From: Contact Centre (CRM) <contact@ribblevalley.gov.uk>
Sent: 29 September 2024 18:19
To: Planning
Subject: Planning Application Comments - 3/2024/0678 FS-Case-650665518

Planning Application Reference No.: 3/2024/0678

Address of Development: 10 Manor Road, Whalley BB7 9TE

4 PROPOSED SOUTH  
1 : 50

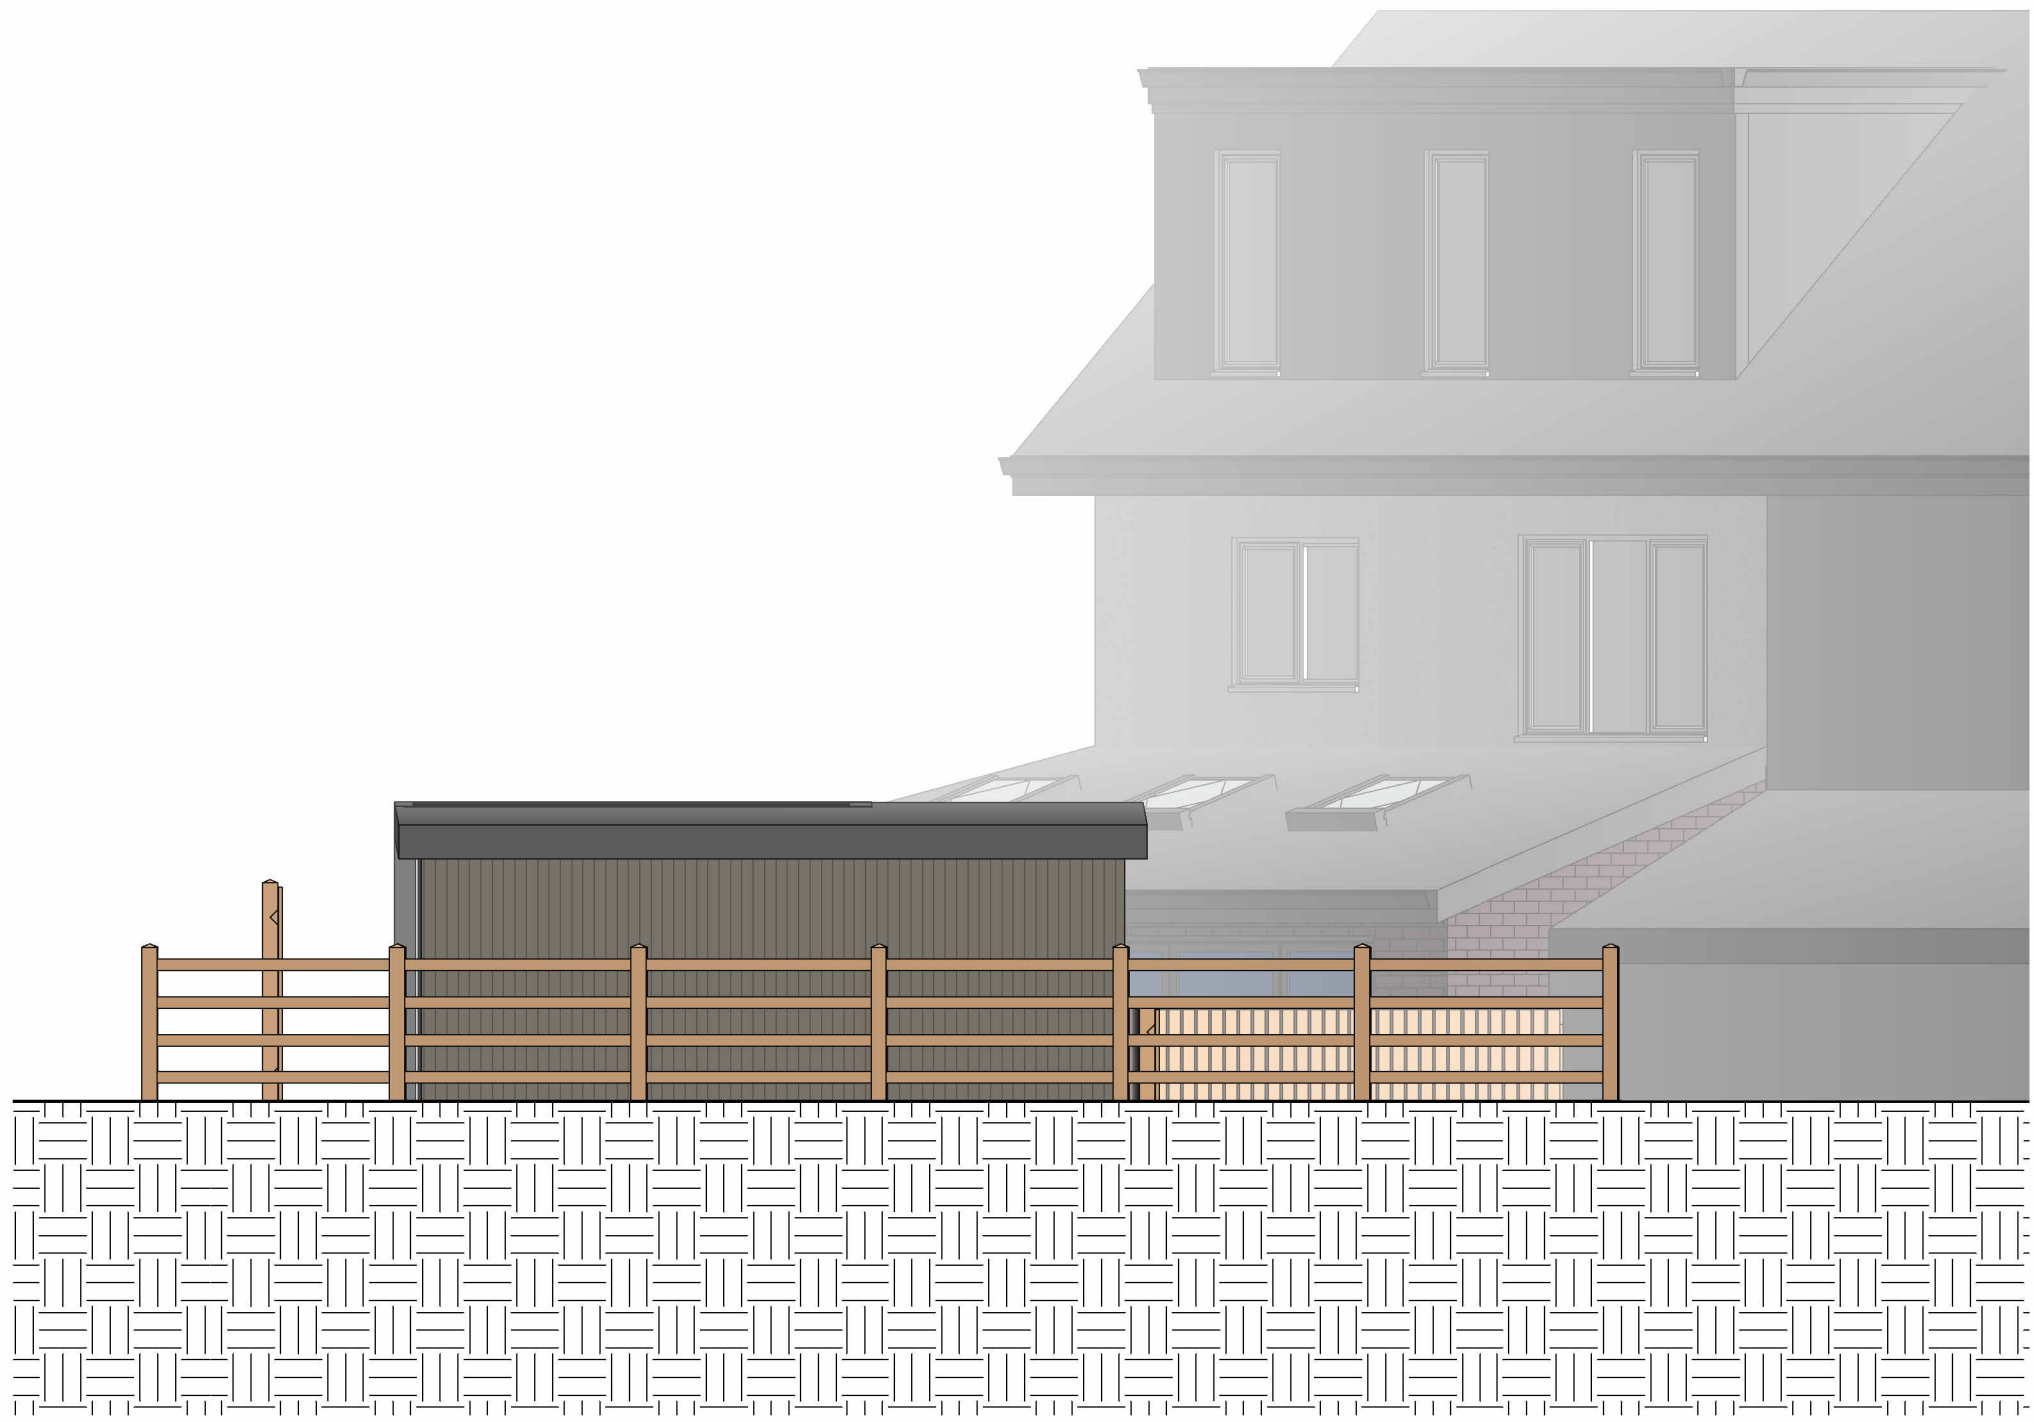
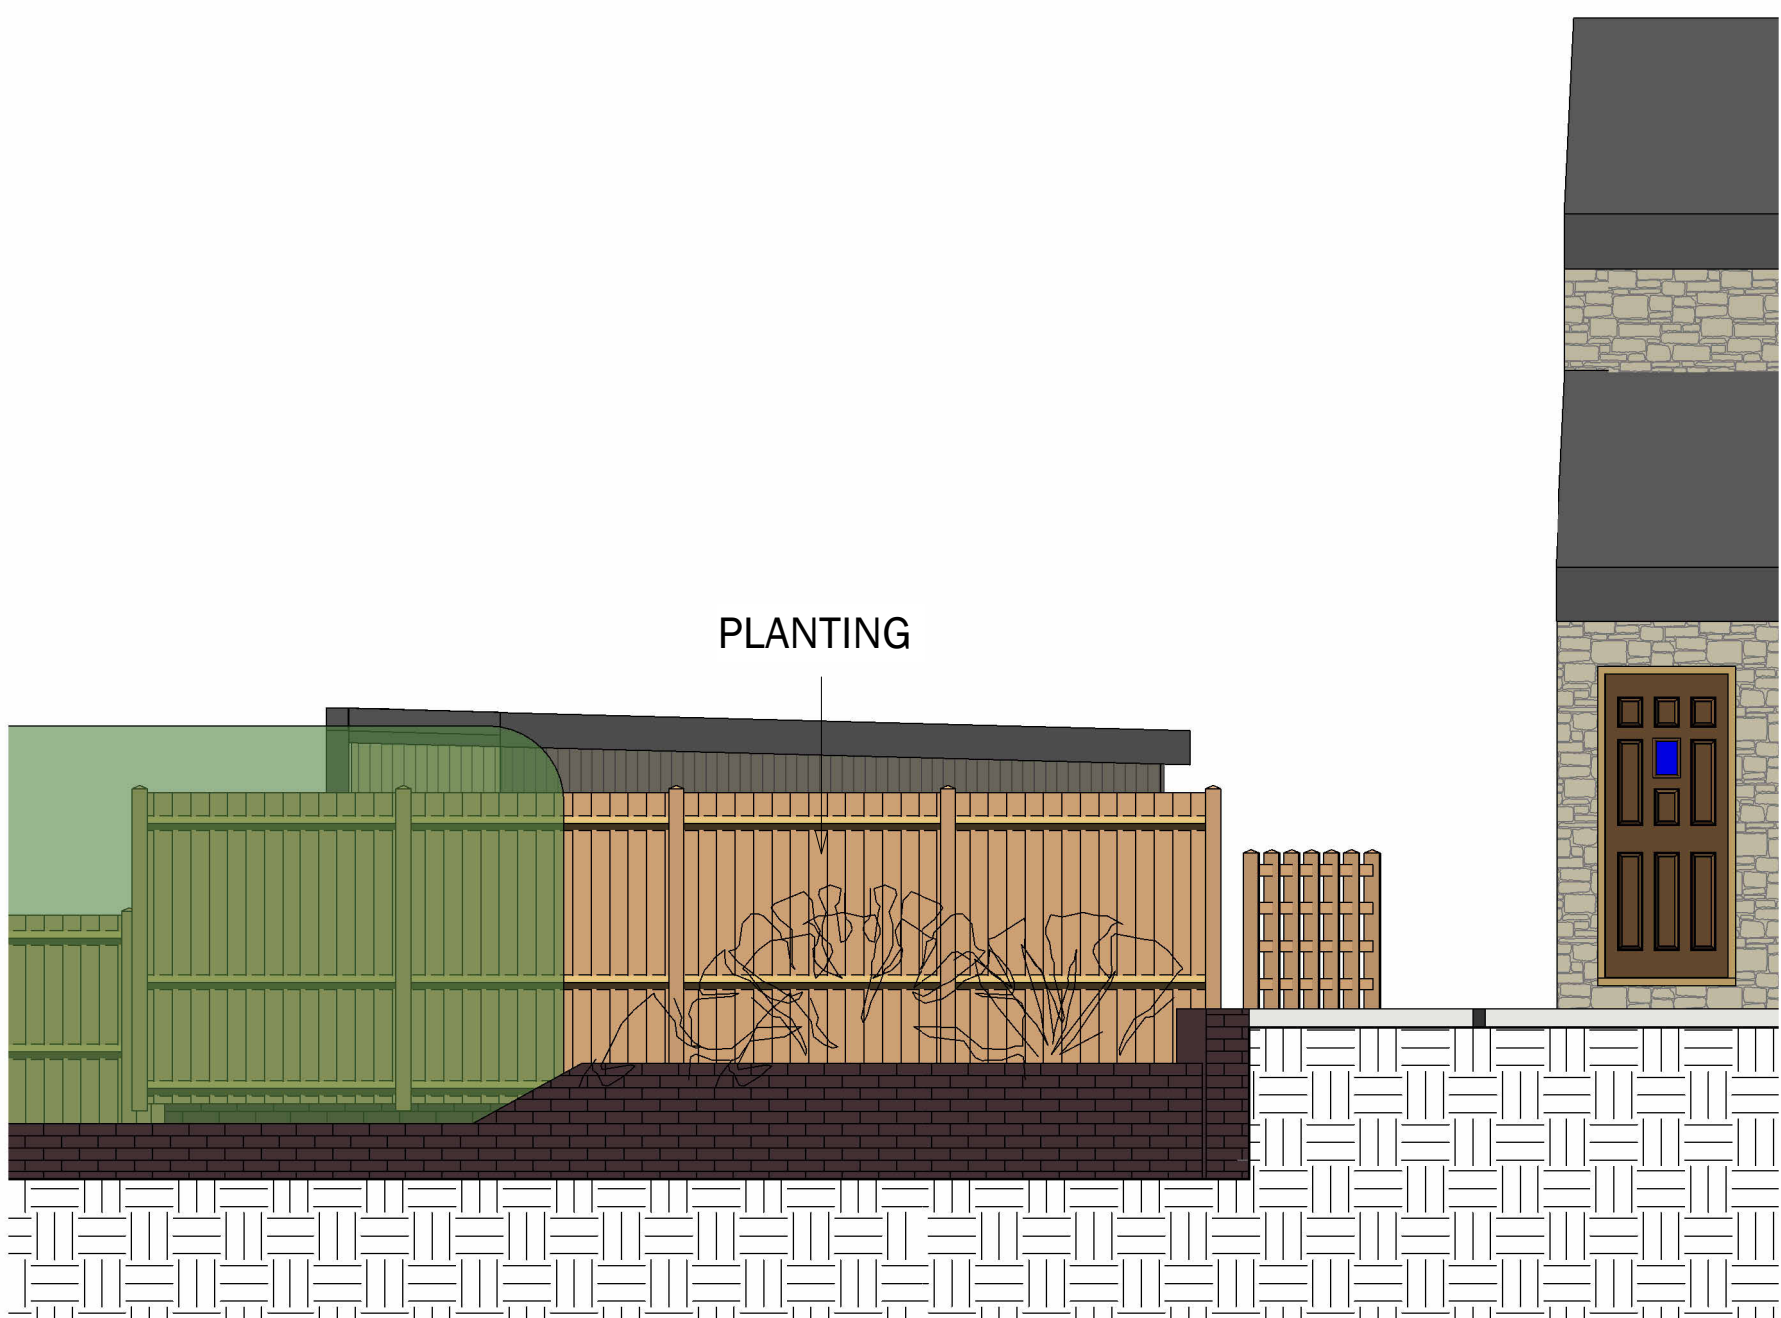
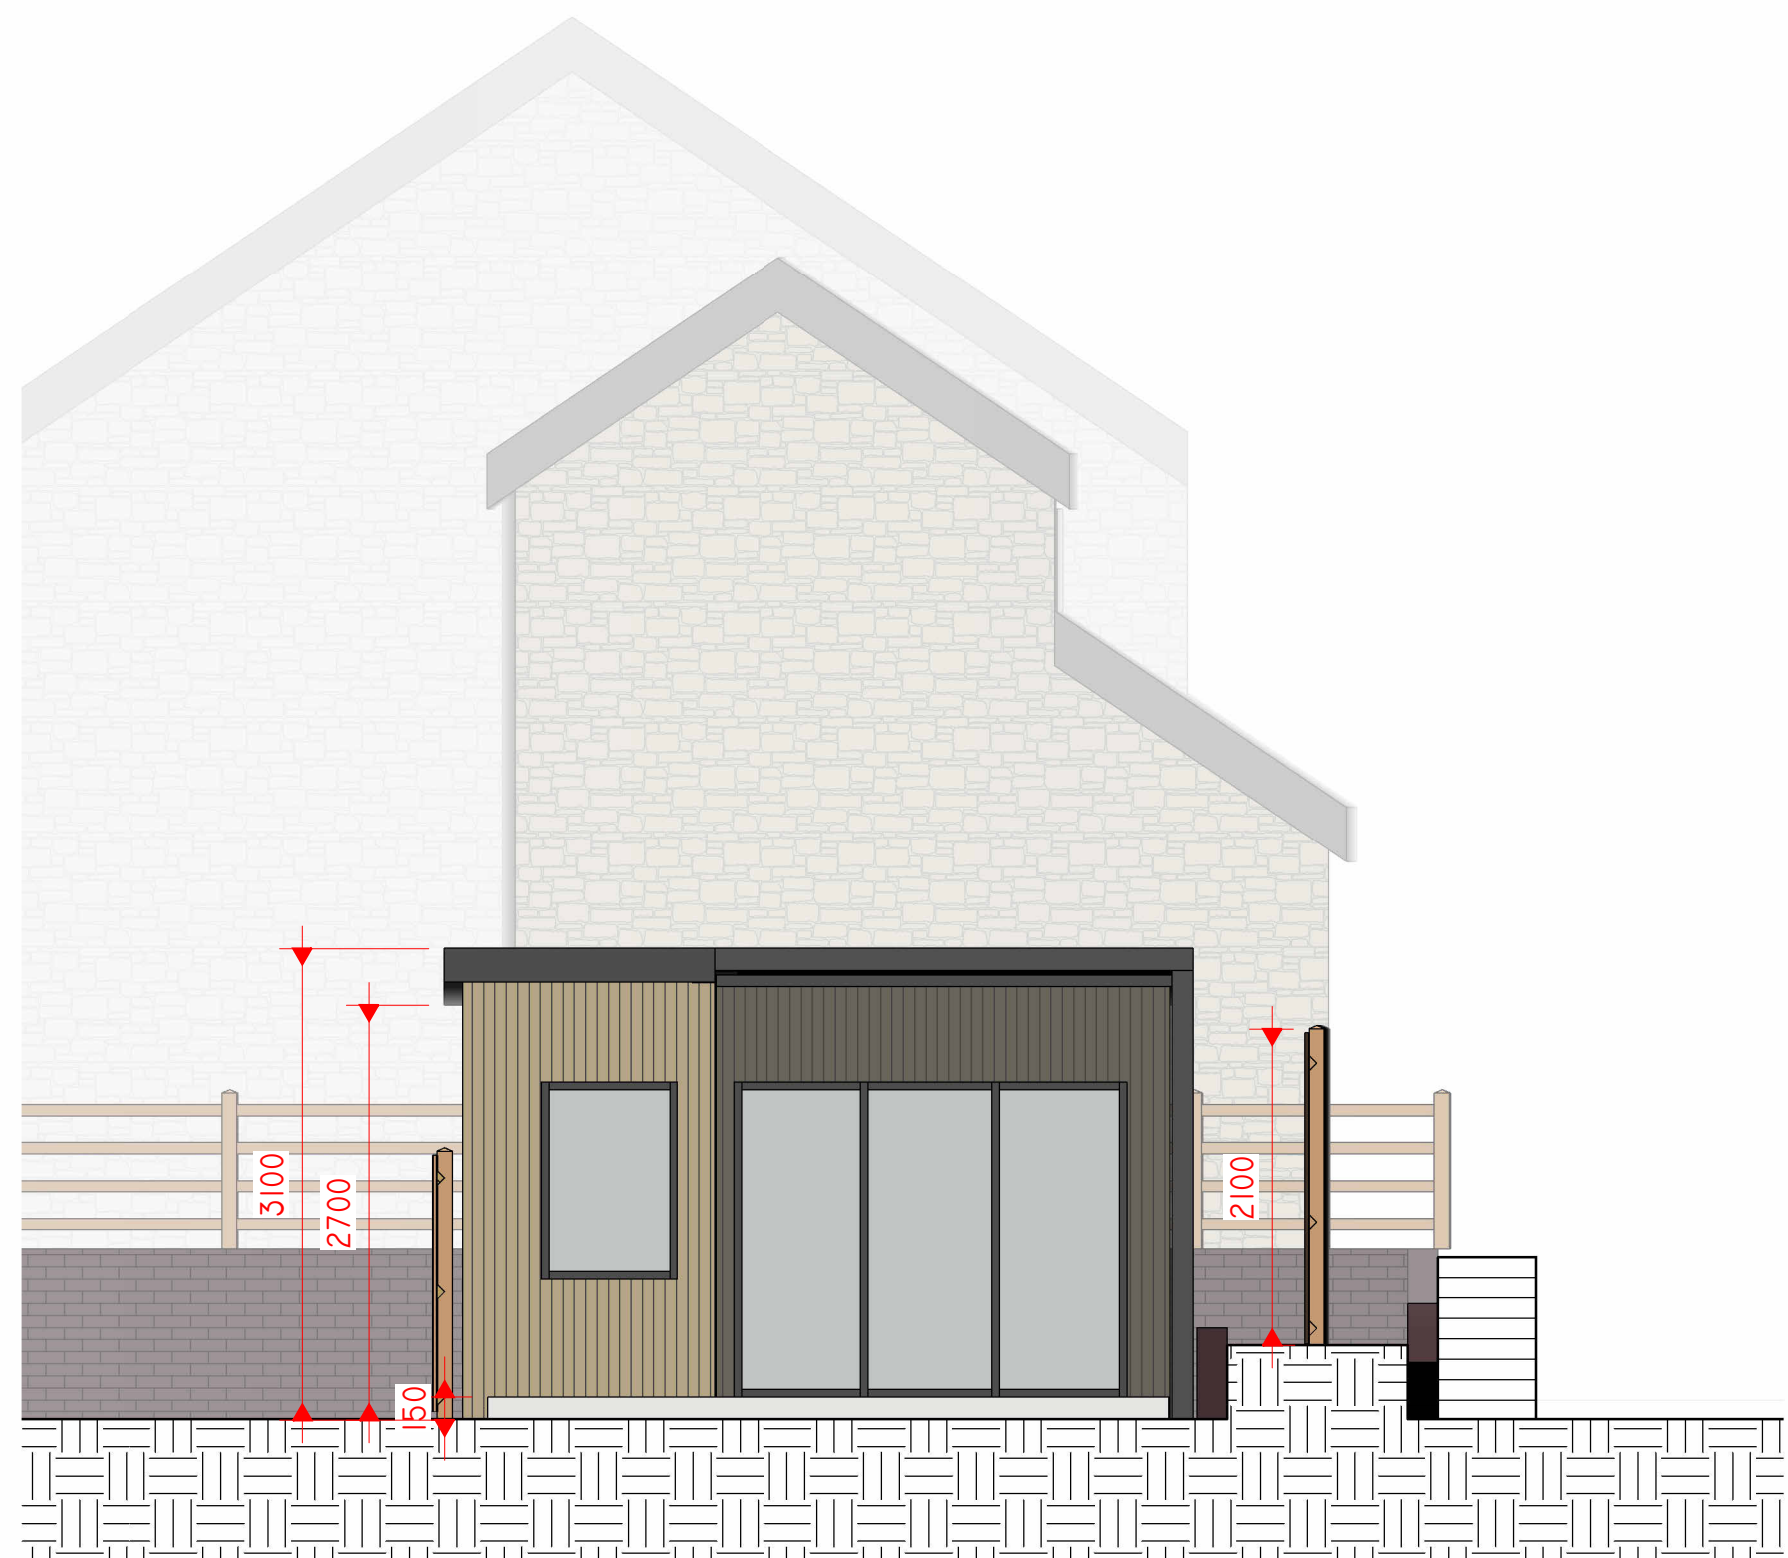
1) Sight lines - I believe the elevation drawings are misleading, because when looking at the south elevation [REDACTED]
[REDACTED]). Therefore we would like to better understand what would be visible from the gyms glazed elevation when looking out and [REDACTED]
[REDACTED]
